**** **FIELD CHANGE LETTER** ****

PROJECT #: 21-2967.-A.2 (Lot 29)

LOCATION: Lot 29, Woodbridge South

PLANS REF: The Clayton with 2nd Floor – Low Country Elevation by South Designs
Project #: 21-2967.1-GL (sealed 1-12-24)

S-2.2

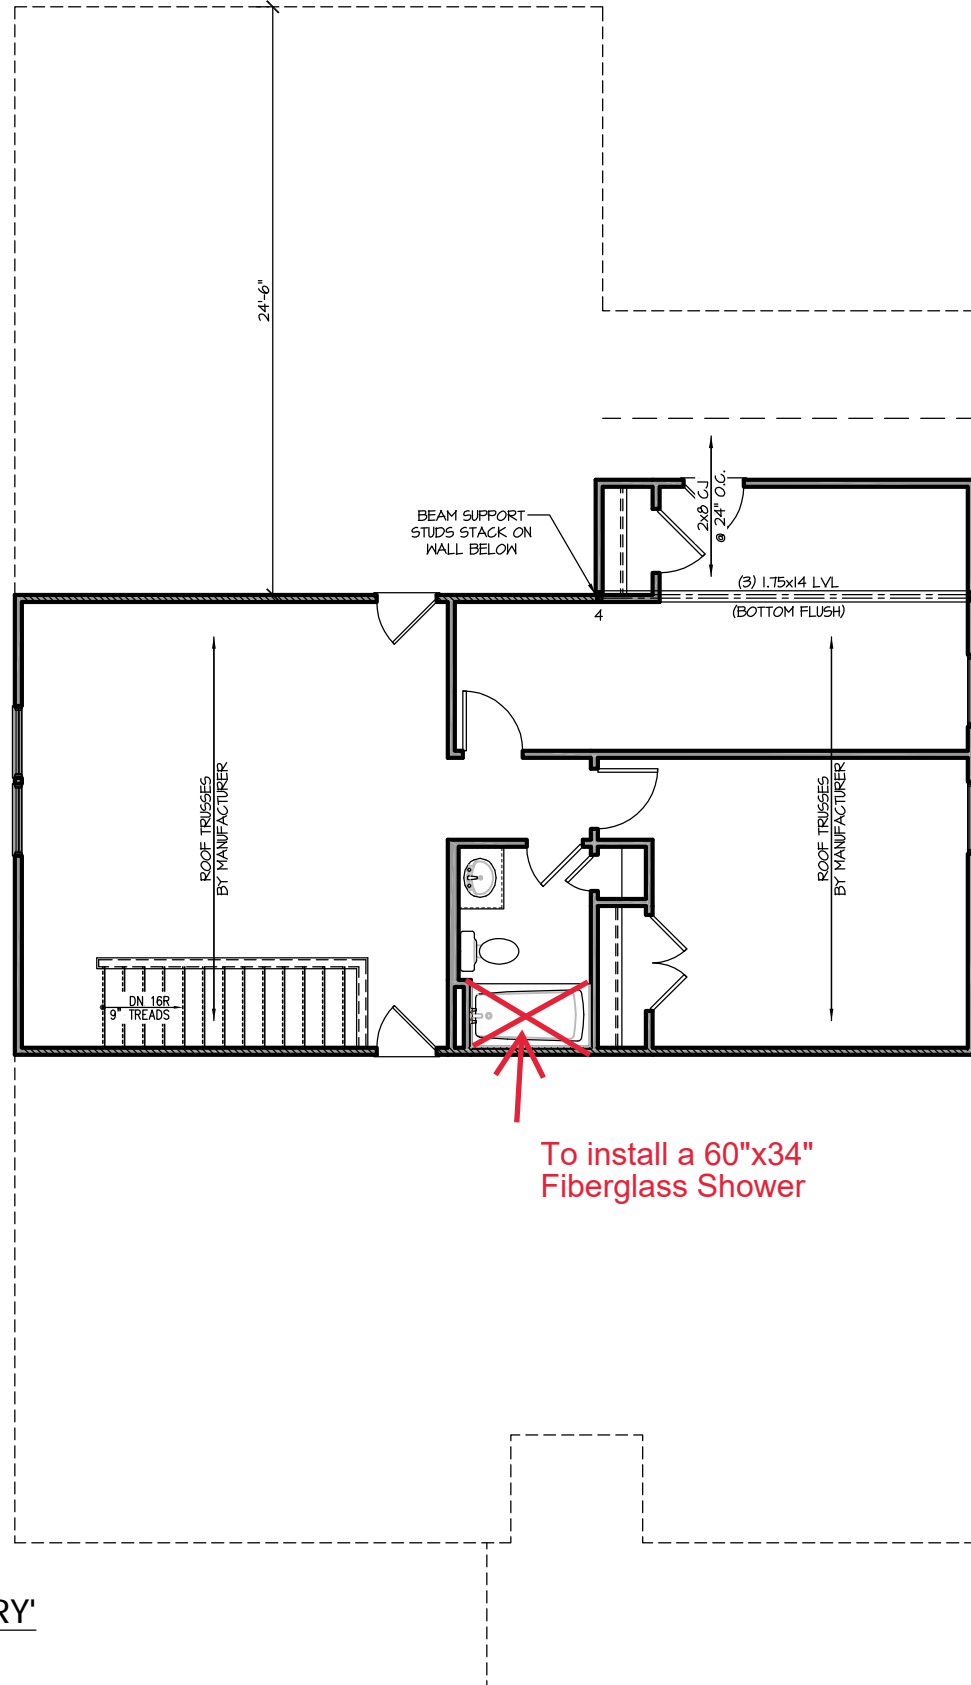
Relocated Truss Support Beam: Sheet S-2.2.2 of the plans shows a (3)1.75x14 LVL spanning left-to-right across the ceiling of bedroom #5. Based on the roof and floor truss placement plans (Job #: J0224-0868 and J0224-0869 dated 2/16/24 by ComTech) the bearing of the roof trusses was not in this location. The front and rear roof trusses were supported by a (3)1.75x18 LVL under the rear wall of bedroom #5. A 2x12 was attached to the back side of the (3)1.75x18 LVL and the front end of the rear roof trusses are hangered to the 2x12. This shifts the loads from the beam approximately 4'-10" to the rear of the original location. The left end of the (3)1.75x18 LVL and 2x12 lines up within the open span of the (3)2x10 girder below. The crawl space access is shifted back from the location shown on the plans and the right end of the beam is supported at approximately 12" from the front end of the access door header. The header above the access door is built from a 1.125x11.875 LSL rimboard, a 1.75x11.875 LVL, and a 2x10 with a ripped 2x stacked above the 2x10. Each member of the header is continuous across the opening and the header is supported on a minimum of (3)2x4 cripple studs at each end.

Response: Please note that the above described relocated truss support beam will be structurally acceptable provided that the 2x12 is attached to the (3)1.75x18 LVL with (2) rows of Simpson SDW22634 screws @ 12" O.C.

Also note that a 1.75x9.25 LVL shall be added to the (3)2x10 girder span that now supports the end of the (3)1.75x18 LVL and 2x12 beam. Attach the LVL to the (3)2x10 girder with (2) rows of Simpson SDW22634 screws at 16" O.C. At the crawl space access, the three plies of the header shall be attached with (4) rows of 12d nails @ 12" O.C. from each side.
